## **BCA ASSESSMENT REPORT**

### **PORT BOTANY INDUSTRIAL ESTATE**

Revision 04

Date: 18<sup>th</sup> December 2014

SITE PLAN- GROUND
1:750 @ A1
December 2014
4244_DA-02
© copyright nettleton tribe partnership Pty Ltd

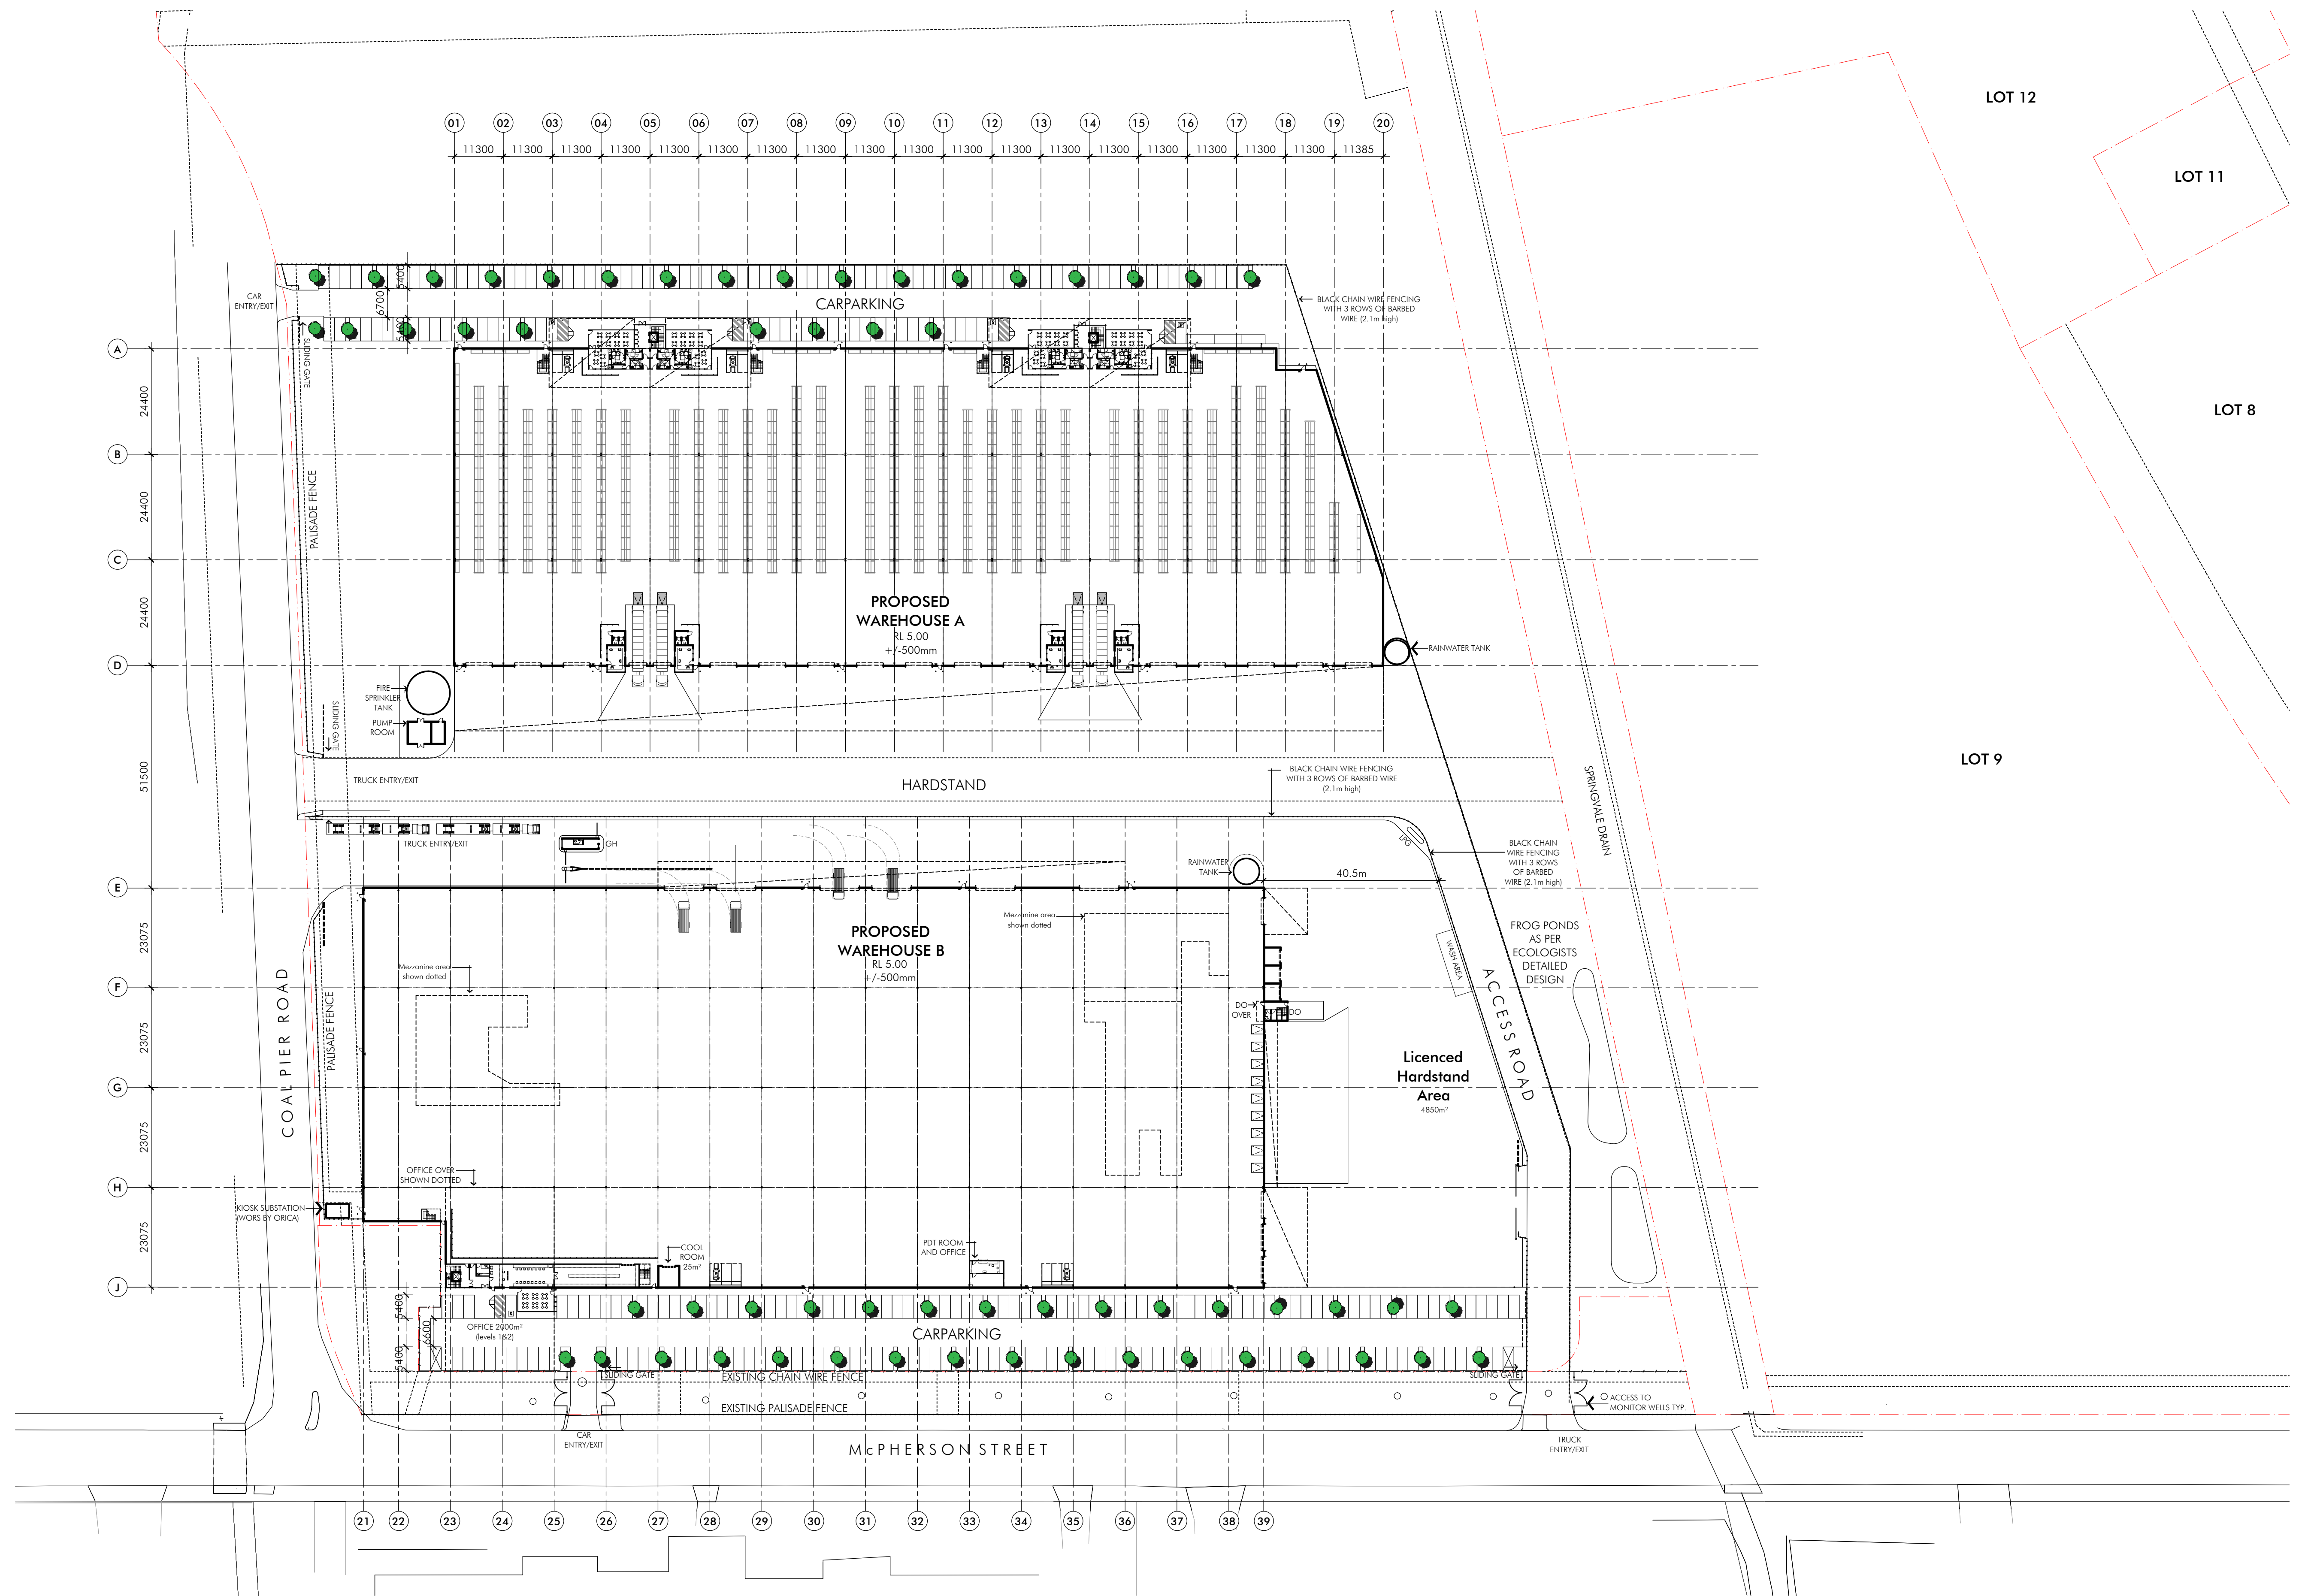
*Comments:* The perimeter access roads and turning bays will generally be designed to comply with the BCA and Fire & Rescue Guidelines (Policy No.4) however a few departures have been identified as matters requiring further attention by the project Fire Safety Engineer.

1. Vehicular Access will only be provided around three (3) sides of the building and is therefore discontinuous along the Eastern side due to site constraints associate with the Flood Storage Areas on the site. Suitable turning provisions will however be available along the Southern and Northern sides to facilitate brigade operations.
2. Additionally, the Western side will have the furthest part of the required 6m access road located at distances greater than 18m from the external walls of the building (approx.47m).

3. Vehicular Access will be provided around all four (4) sides of the building however the Western & South-Western side will have the furthest part of the required 6m access road located at distances greater than 18m from the external walls of the building (distances ranging between 21m and 42m).
4. Additionally, access to the site from McPherson Street necessitates brigade vehicles crossing via a separate allotment which will have a Right of Carriageway.

**Note:** The above non-compliance issues are required to be addressed as an Alternative Solution by the Fire Safety Engineer to demonstrate compliance with Performance Requirements CP9.
